Application for Removal or Variation of a Condition following Grant of Planning Permission or Listed Building Consent

Number	1
Suffix	
Property Name	
Address Line 1	Woodside Road
Address Line 2	
Address Line 3	Hillingdon
Town/city	Northwood
Postcode	HA6 3QE

Erection of a two storey extension to the side and front, erection of a single storey extension to the rear, erection of front porch, following the demolition of existing conservatory, porch canopy and shed.

13426/APP/2024/3060

DRAWING NUMBER:
447-009

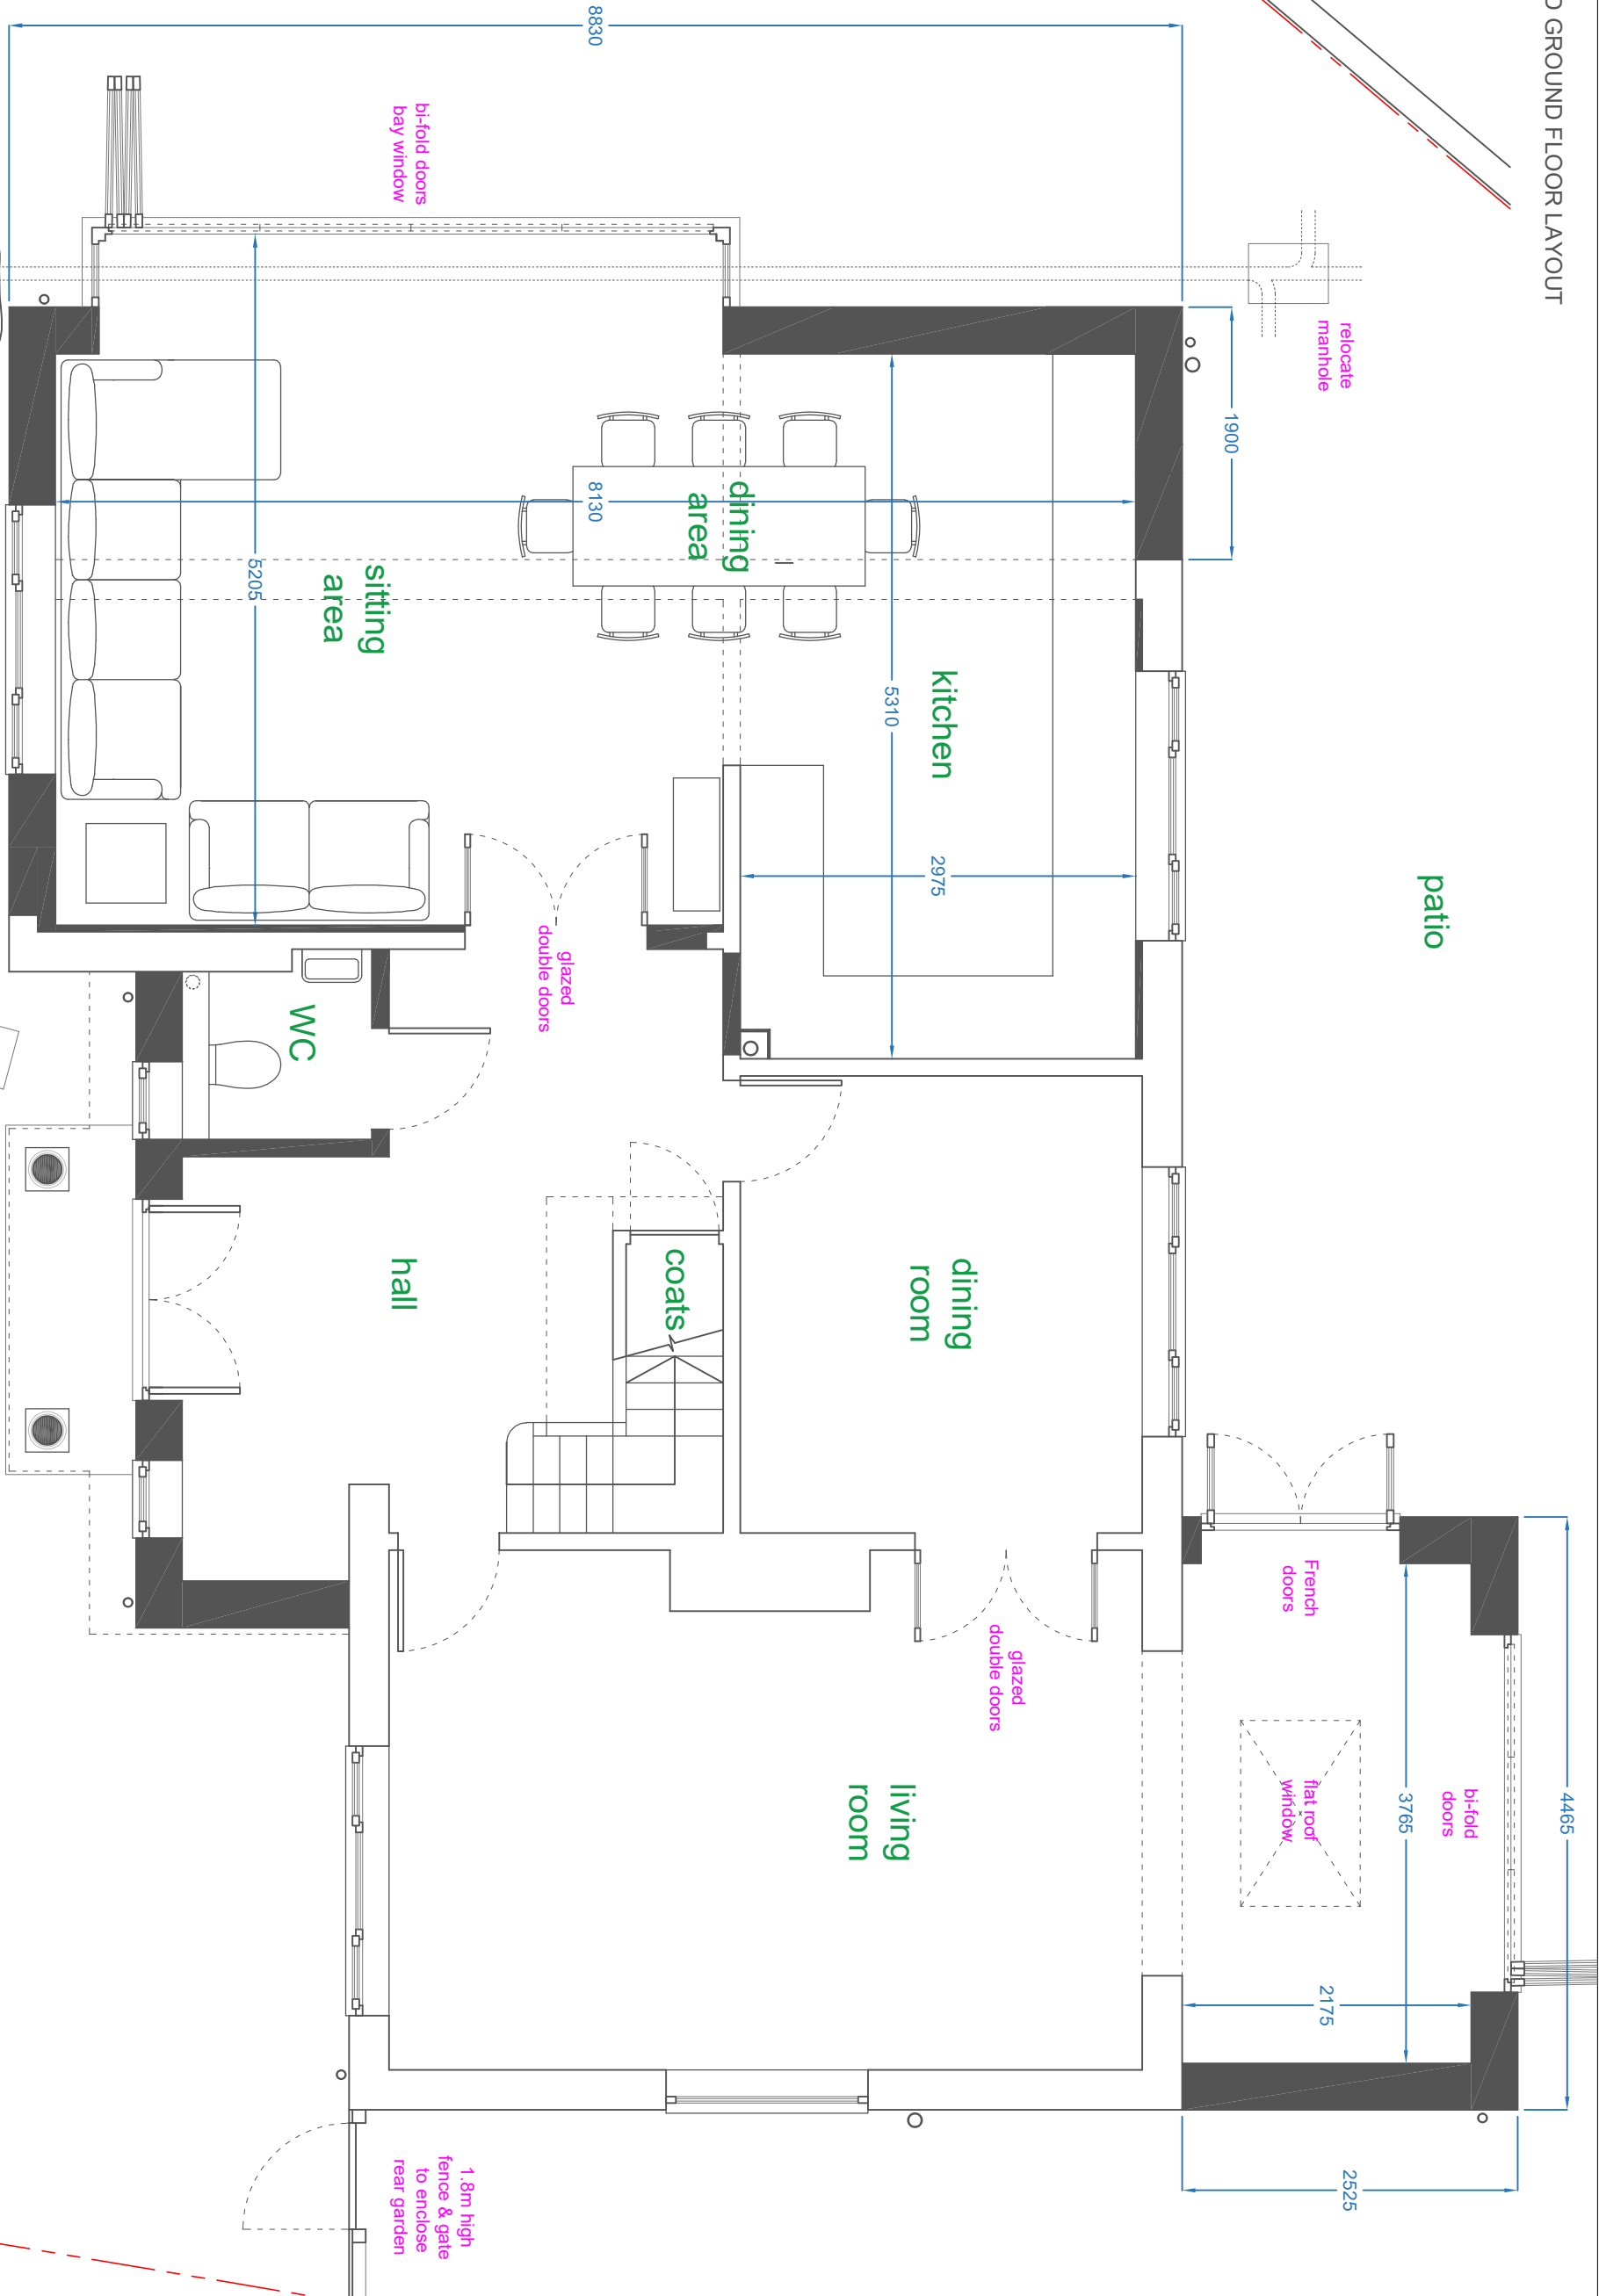
Amending the porch design with the inclusion of buff coloured columns.

Drawings 447-009C, 447-011C & 447-012A changed to 447-009D, 447-011D & 447-012B.
